Planning Application Ref: **AW/357/20/HH**

Location: **Land Between 8 And 12 10 Wychwood Close, Aldwick, PO21 4DW**

Description of works: **Outbuilding in rear garden. (This application may affect the setting of the Craigweil Conservation Area).**

FOR MR & MRS HARTLEY		
SITE 10 WHYCHWOOD CLOSE, ALDWICK, WEST SUSSEX		
TITLE PROPOSED GARDEN ROOM BLOCK PLAN		
SCALE 1:500 © A3	DRAWN AH 12/20	DRAWING NO. 01B REV. A

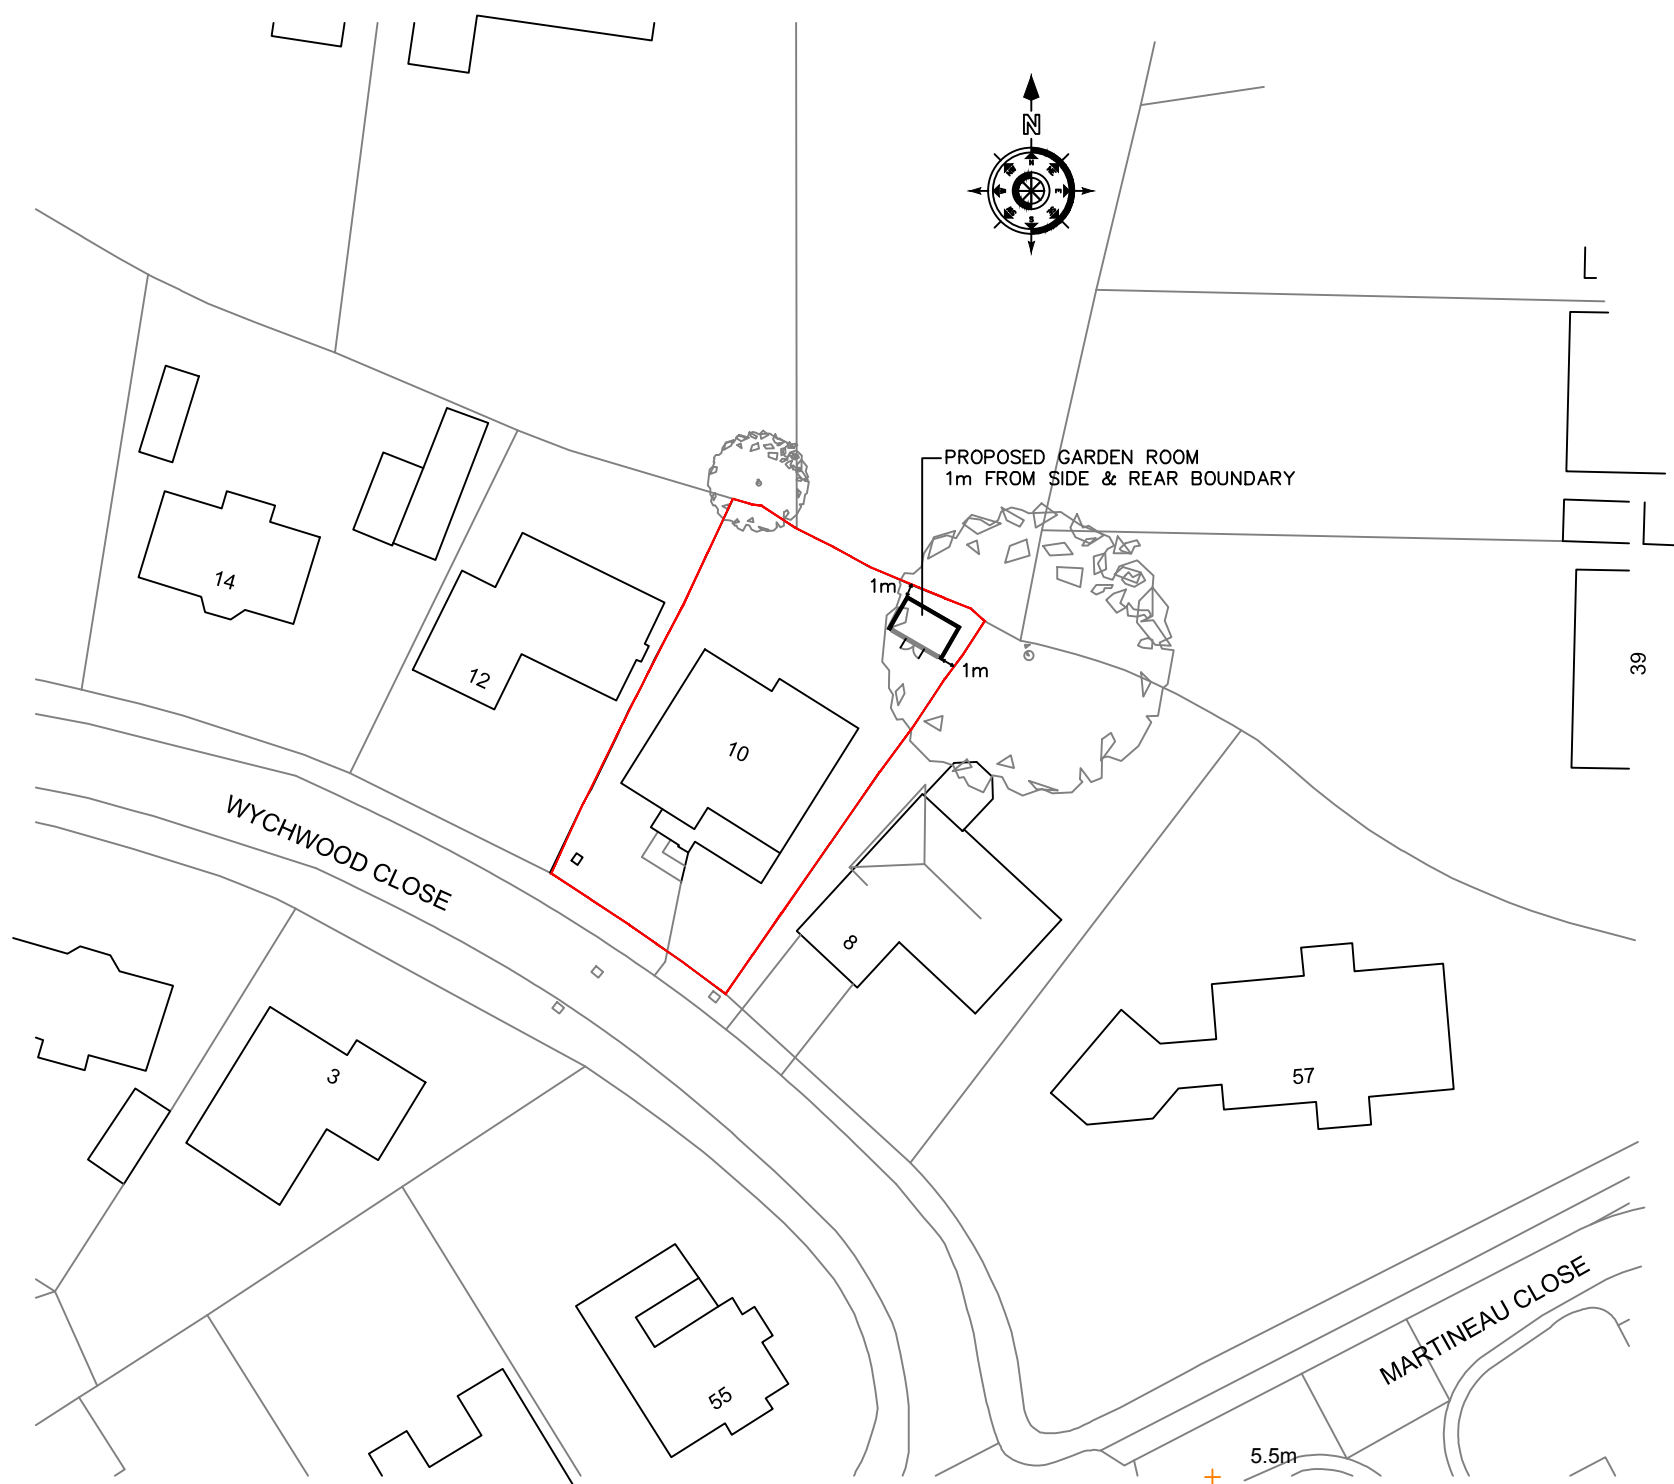
- It is stated that no trees or hedges would need to be removed or pruned in order to carry out this proposal. That said, the building footprint appears to be sited within the crown spread and probably within the nominal root protection area (RPA) of an established off-site oak tree, and potentially those of other trees to the north. As such, there is potential for damage occurring to those trees during ground preparation and installation of foundations. Furthermore, installation of any services/utilities may need to be routed through RPAs.

- The principle of development may be achievable without undue detriment to significant off-site trees, although we are yet to have sight of the necessary arboricultural report and plans to demonstrate this has been properly considered.
- It may now be preferable for the applicant to re-position the outbuilding outside of any RPA or crown spread, to both eliminate risk of harm to/interference from, established trees of amenity value and reduce arboricultural input for the project.

1. As it stands, the applicants will need to employ the services of an Arboricultural Consultant to carry out a tree survey exercise and then prepare an Arboricultural Impact Assessment (AIA) which must be inclusive of; a 'Tree Survey Schedule', a 'Root Protection Area (RPA) Schedule' and a 'Tree Constraints Plan' – with the trees accurately plotted on same.
2. In the event that a RPA of any tree which is proposed for retention overlaps the development then BS5837:2012 requires that the Detailed Planning Application is accompanied by an Arboricultural Method Statement (AMS) and also most importantly a Tree Protection Plan – to both describe and illustrate the mitigation measures which are to be employed to ensure that the trees survive without detriment to their vigour and vitality and are given adequate protection both above and below ground.
